Address: 32, Knowl Road, Mirfield, WF14 8DJ

Application number: 2026/91303	
What is the application for?:	Erection of detached garage
Address of the site or building:	30, Knowl Road, Mirfield, WF14 8DJ
Postcode:	WF14 8DJ

Proposed Site Plan
1 : 500

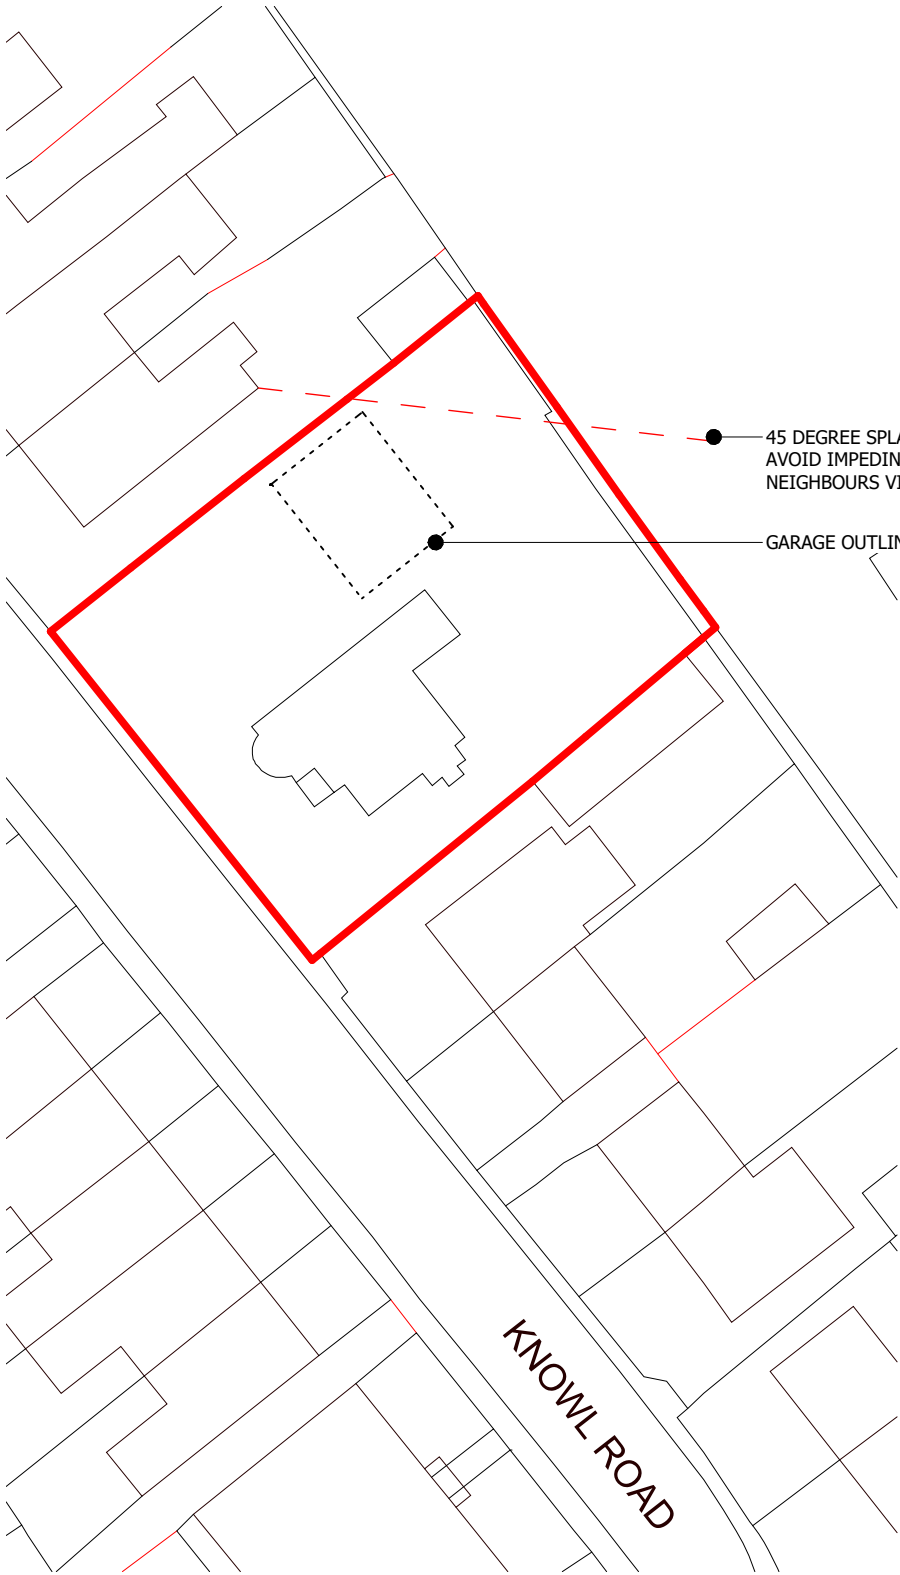
Type of comment: An objection	
Do you wish your comments to be published on the website anonymously?	No
We are the occupiers of 32 Knowl Road, Mirfield, and write to formally object to the above application for a detached double garage at 30 Knowl Road. 1. Impact on Residential Amenity – Overbearing Development The proposed garage is positioned in close proximity to the shared boundary with No. 32 Knowl Road. Based on the submitted site plan, the separation distance between the proposed structure and the side elevation of No. 32 appears to be approximately 5–6 metres. We feel that this distance is insufficient given the scale, massing, and siting of the proposed building. The garage is not a minor structure but a substantial double garage with a significant roof form and ridge height, which would introduce a permanent and prominent built form adjacent to the neighbouring boundary. We are concerned that the proposed building may create an overbearing and enclosing effect when viewed from the garden of No. 32. 2. Loss of Outlook and Visual Amenity No. 32 has a primary kitchen window located on the side elevation, which provides an important source of outlook and natural light to a principal habitable room. The submitted plans suggest that the garage would occupy a dominant position in close proximity to this window, reducing openness and outlook. The development would replace an otherwise open aspect with a substantial built form, potentially resulting in a noticeable reduction in visual amenity for the occupiers of No. 32. 3. Principle of Adequate Separation Distances We understand that there is no single fixed statutory separation distance in planning policy; however, established design guidance and planning appeal decisions generally recognise that adequate separation between substantial outbuildings and principal windows of neighbouring dwellings is important to safeguard residential amenity. A separation distance in the region of 10–12 metres is often referenced in design

In this case, the proposed separation of approximately 5–6 metres appears materially below what may ordinarily be considered acceptable, particularly given the scale of the proposed garage and the sensitivity of the affected kitchen window.

We respectfully request that the Local Planning Authority refuses planning permission in its current form. We do not object in principle to our neighbours constructing a garage; but prior to this would request that amendments are made to increase the separation distance from the boundary and reduce the overall height of the structure. There is also ambiguity about its proposed position. A desire for increased privacy from our neighbours doesn't seem to align with the position of the build as far as we understand the plans.
